Demolition of existing garage, side porch & roof level store & water tank & construction of a new side extension, new garage & second floor bedroom.

Broadbeach 39 Coastal Road Kingston

Thank you for your internet representation made on 3rd June 2015 which has been recorded as '**an objection**' with the comments as follows:

1419 SK01A
Broad Beach 1:100
Proposed Ground Floor Plan
January 2015

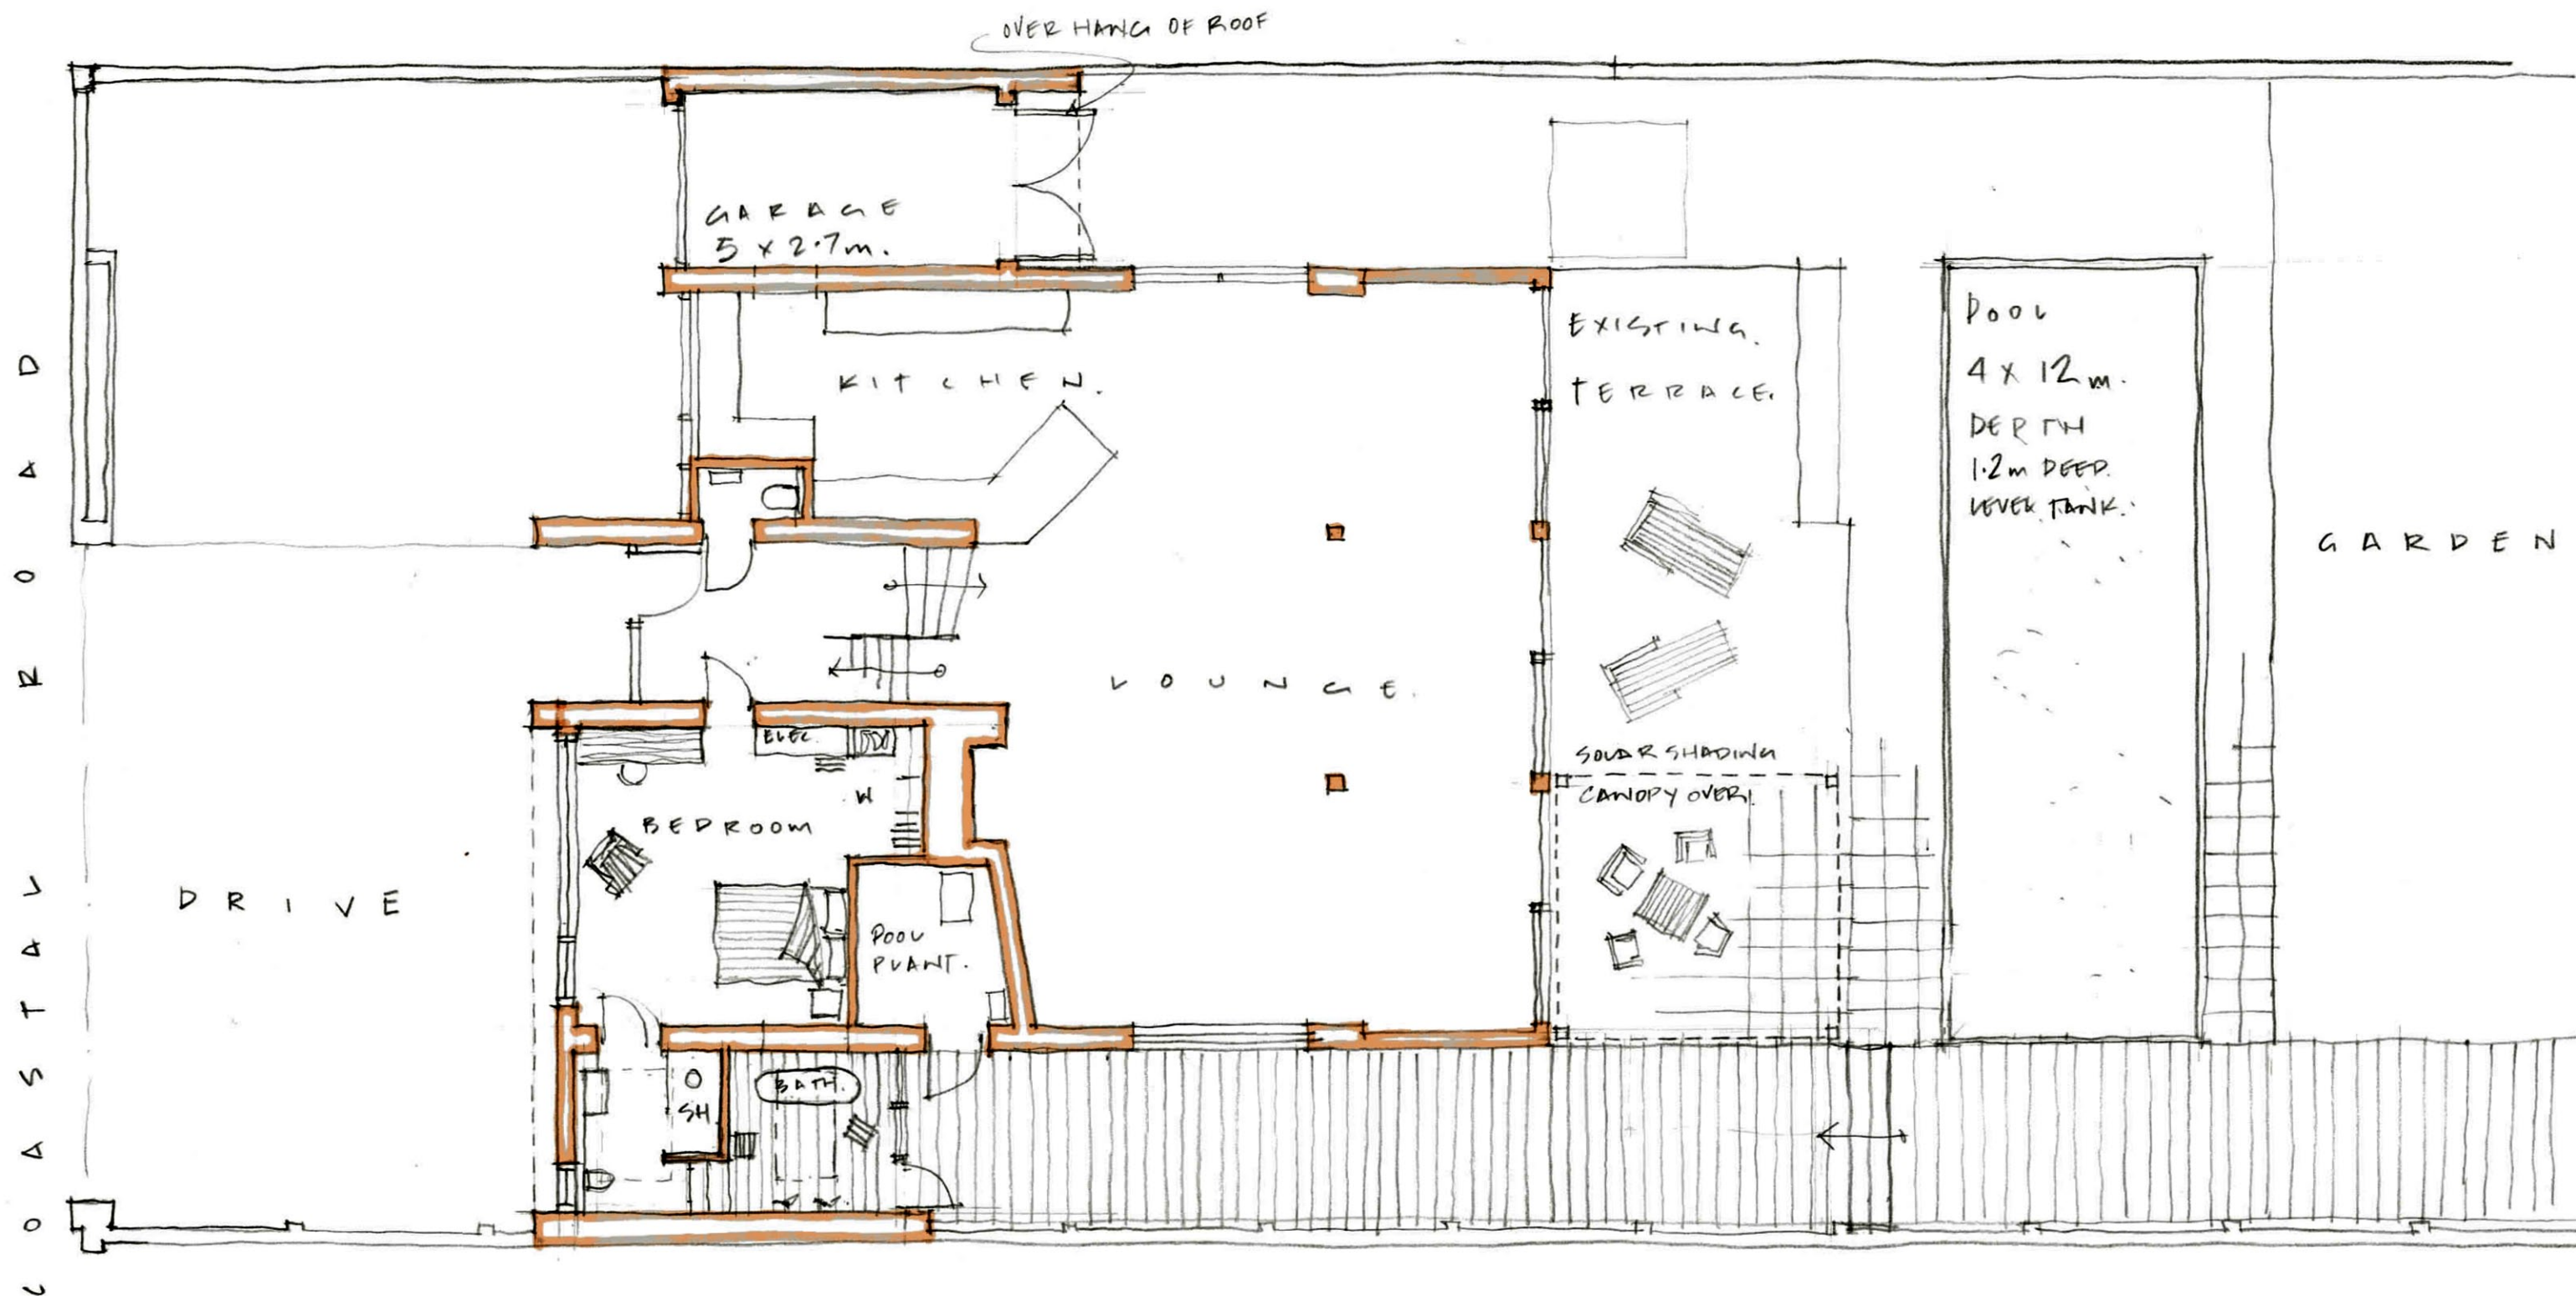
Erection of garage on east side of the property up to the boundary wall would have a detrimental impact on our property. The erection of a garage up to our boundary wall at a height of 3 metres is a further 1.3 metres higher than the existing dividing wall. Whilst the proposed height of 3 metres is only marginally higher than the existing porch as stated in section 2.3 of the design and access statement it is a considerably larger structure 15 m2 footprint vs 2.5 m2 for the existing porch. The existing porch also finishes 1.4m away from the boundary wall, not right up against our boundary.

As an aside, I fail to see how this structure could work as a garage and still allow use of the kitchen door. The reason that the porch is quite so high at the moment (and presumably the extension is proposed to be the same height) is because the kitchen door is not a ground level and the porch contains a series of steps to permit access to the door. Given the width available it would not be possible to have steps to the kitchen door and park a car in the garage.

Proposed Second & Roof Plan

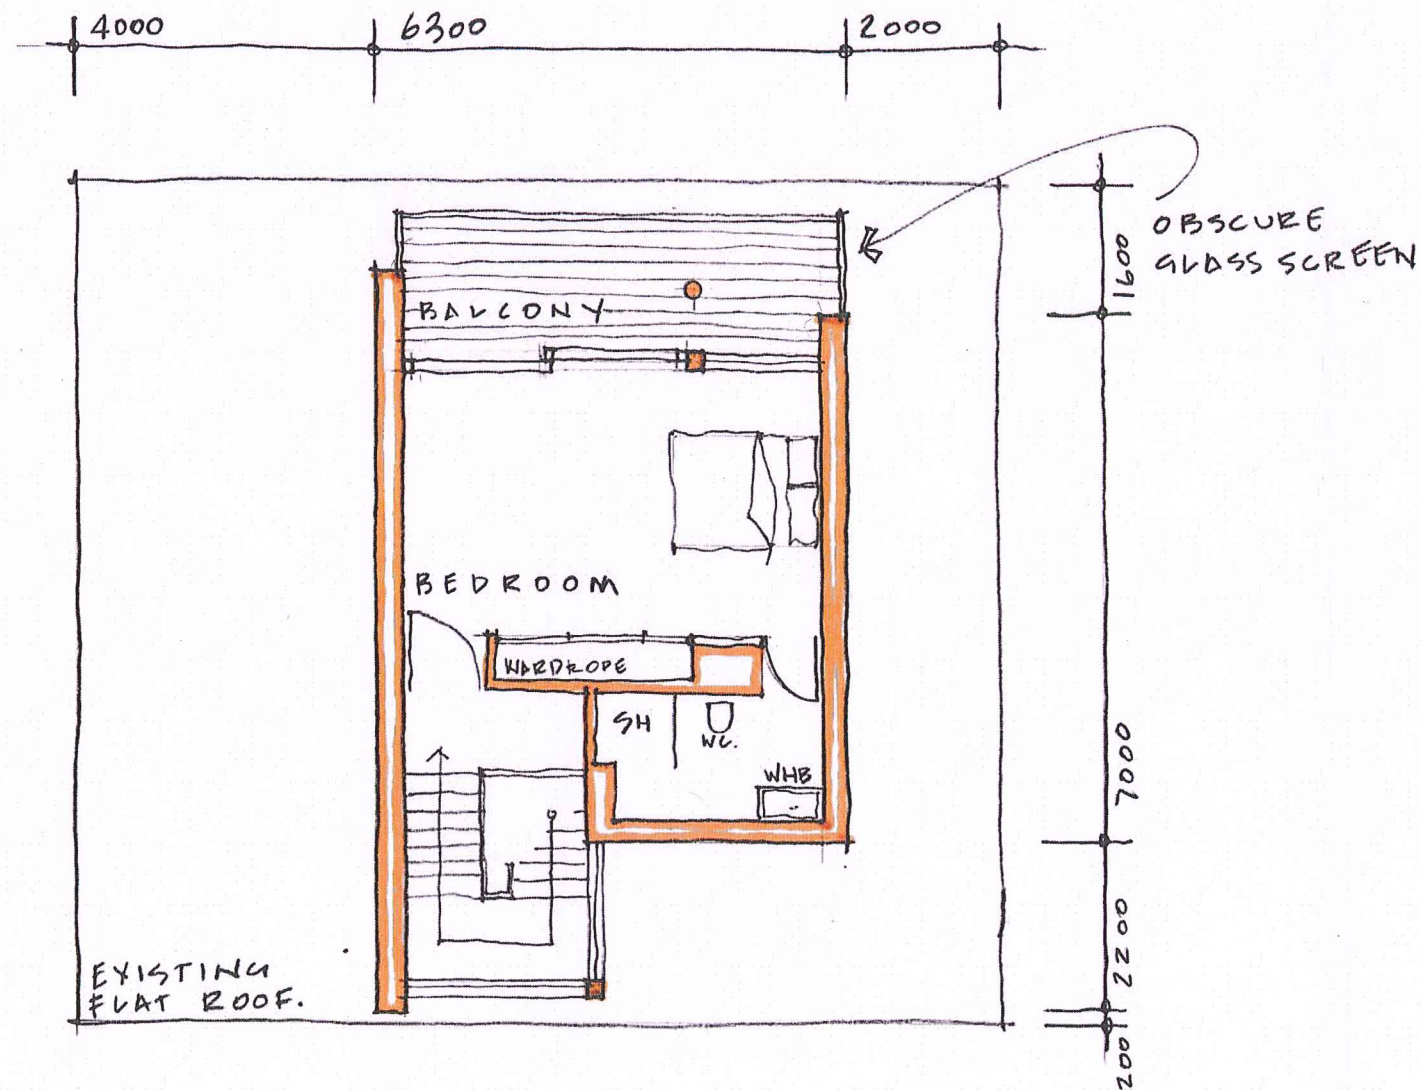
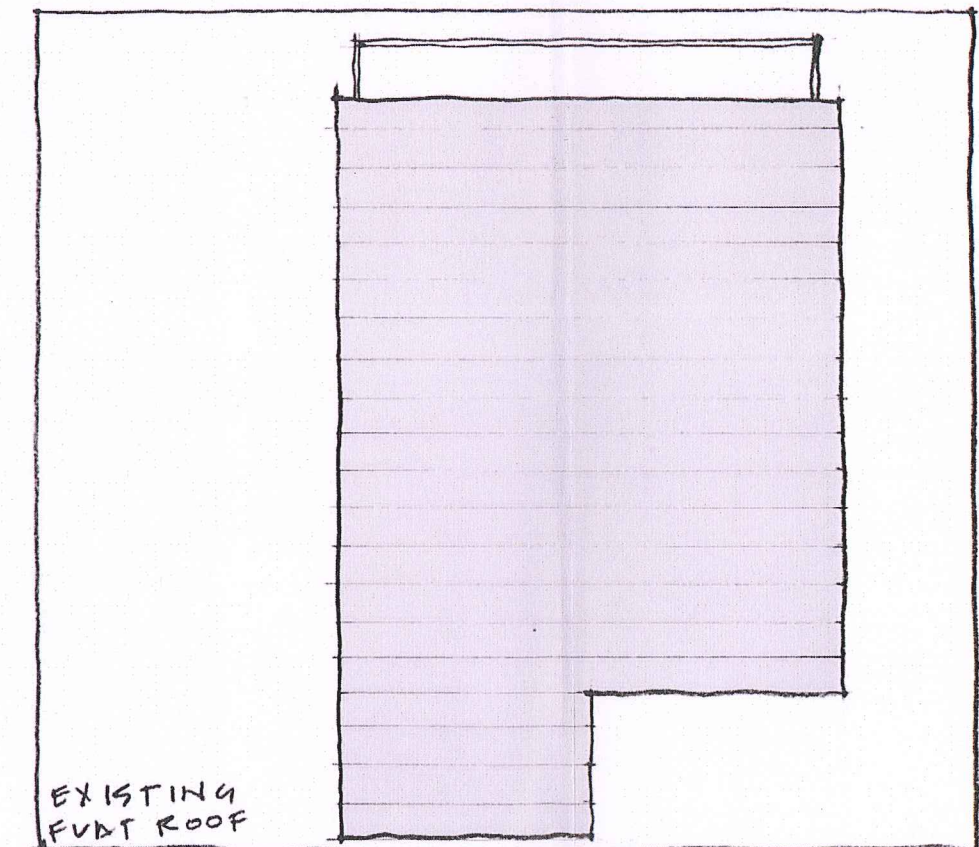
The Second story extension (third floor) balcony would look into the sun room of our house, impacting on our privacy.
